From: [Colin King](#)
To: [Norfolk Boreas](#)
Subject: Norfolk Boreas EN010087 Comments.
Date: 21 October 2021 21:52:40

Title:	Scenario 1 Viewpoint 4: A47 Necton Substation
--------	---

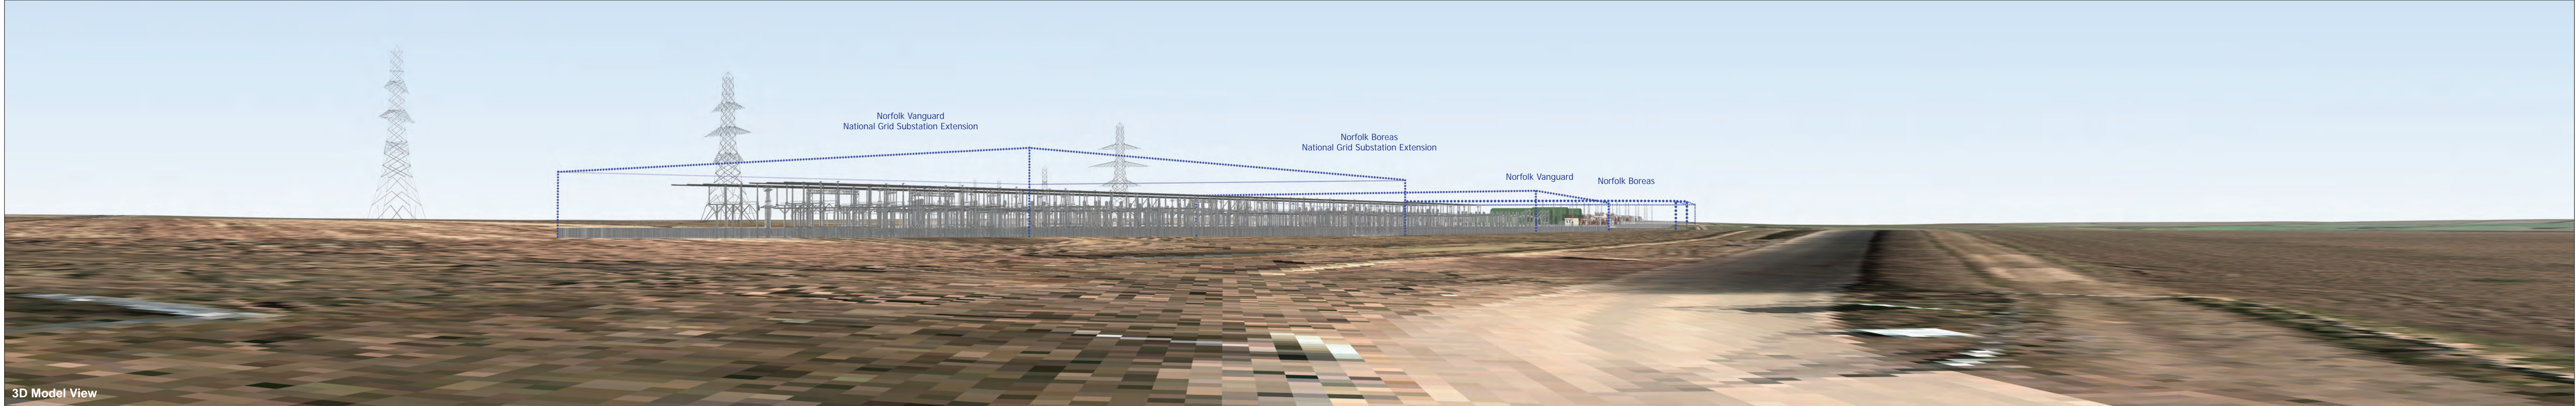
I have tried to point out a problem with the visualisations (only the view points that I live with) and provided possible reasons how they have occurred, and the same with the noise limit set. As it stands I have not had any meaningful answers which provide reassurance and confidence in the project, but instead comments that seem defensive and to also downplay the concern.

These two points alone have major possible implications to the finished combined substations. One affects the foreseen visual impact and therefore requisite mitigation deemed necessary and the other affects the amount of sound allowed to be produced by the substations.
